From:
Sent: 10 November 2024 13:39
To: DC Admin
Subject: Comments for planning application 2024/93080

Here are my comments and objections for the planning application at Bath Works, Lamb Hey, Spa Lane HD75QB

Title
Site plan and sections.

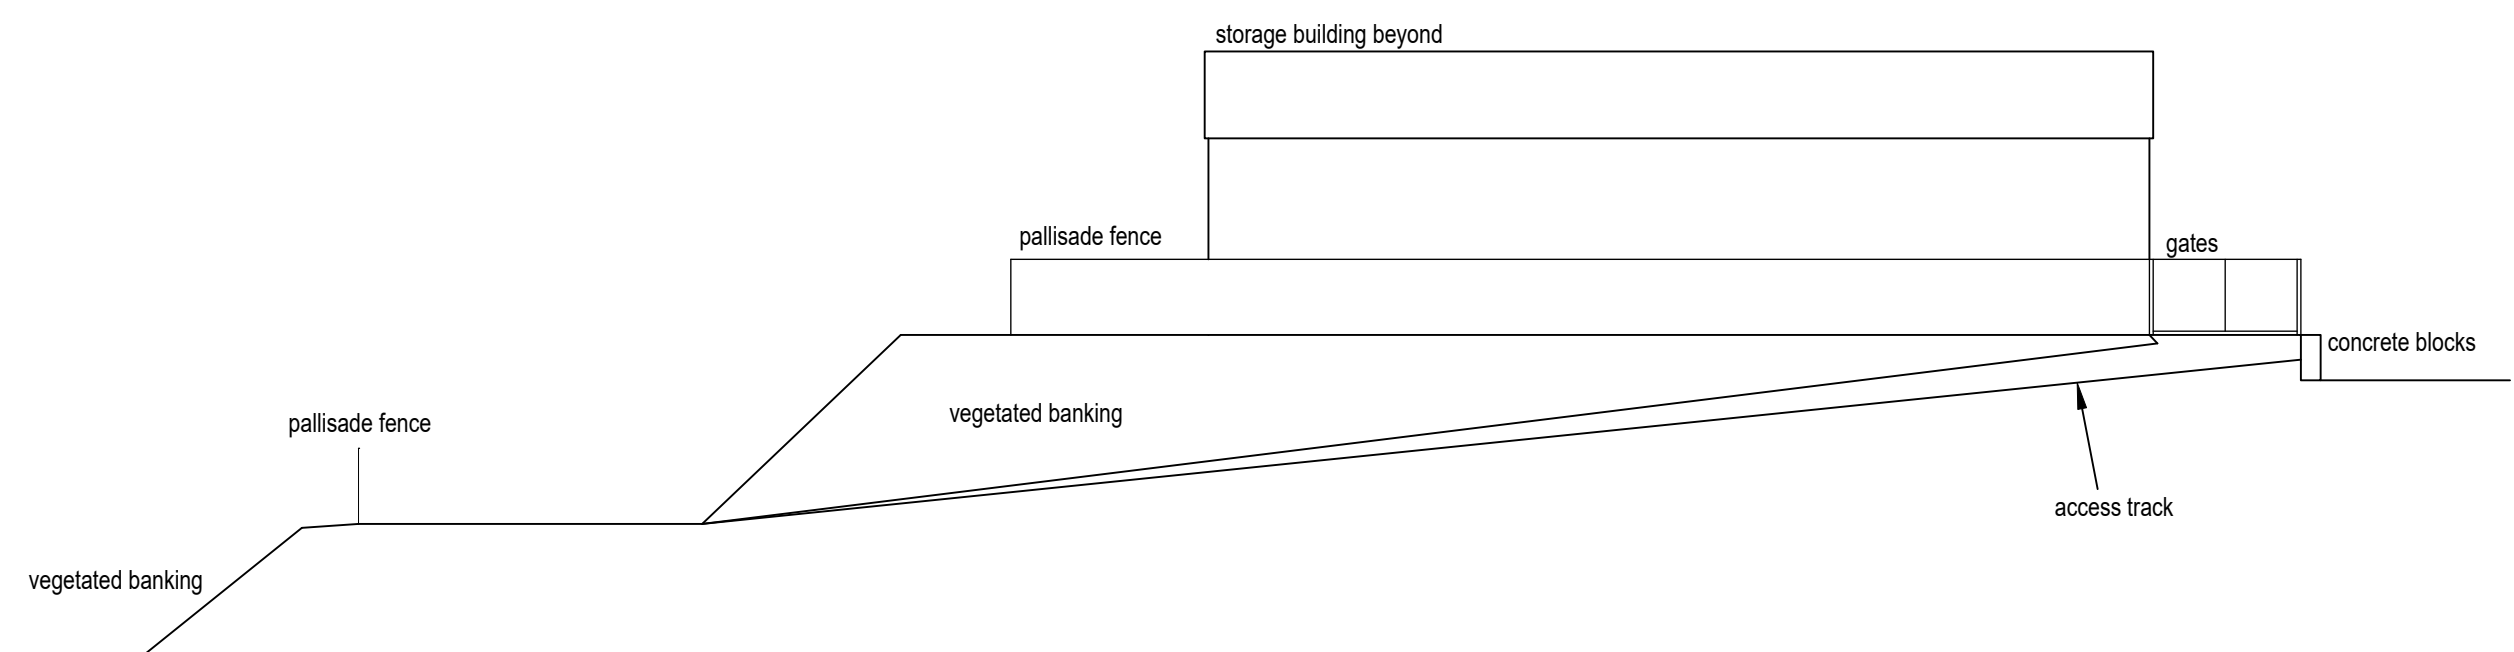
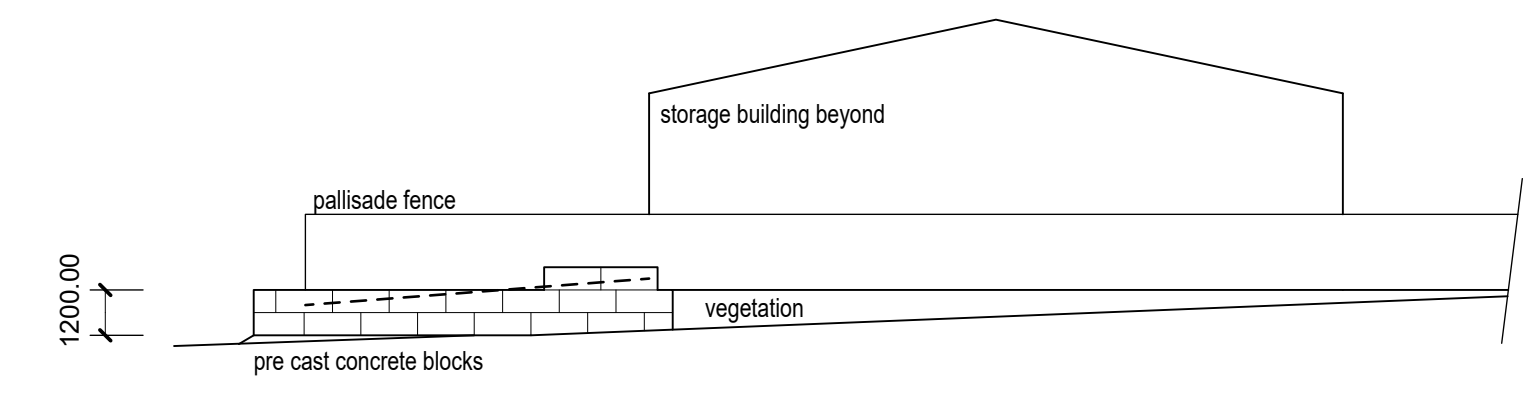
The road is approx. 10 metres wide, 100 metres in length and has increased ground level by approx. 7 foot. There is no retaining wall/ structure and it is on greenbelt.

- Do Powertech have planning permission for this project? There is nothing on the online portal to suggest so. The last application was in 2021.
- There is no retaining wall/structure.

- If they have planning permission, why conduct your affairs in such a questionable way? Your actions immediately arouse suspicion.
- The way in which PowerTec have built this 'access road' is without any retaining wall structure. So what will happen to all of that earth in heavy rainfall? Will it subside on the adjacent land, which is somebodies garden?
- How would you feel, if a company created an 'access road' without any retaining structure and in heavy rains, it may wash into your land?
- In the letter PowerTec wrote to the neighbours they state 'we totally understand industrial premises are not always everyone's favourite choice of neighbour.'. Yet, even though this is
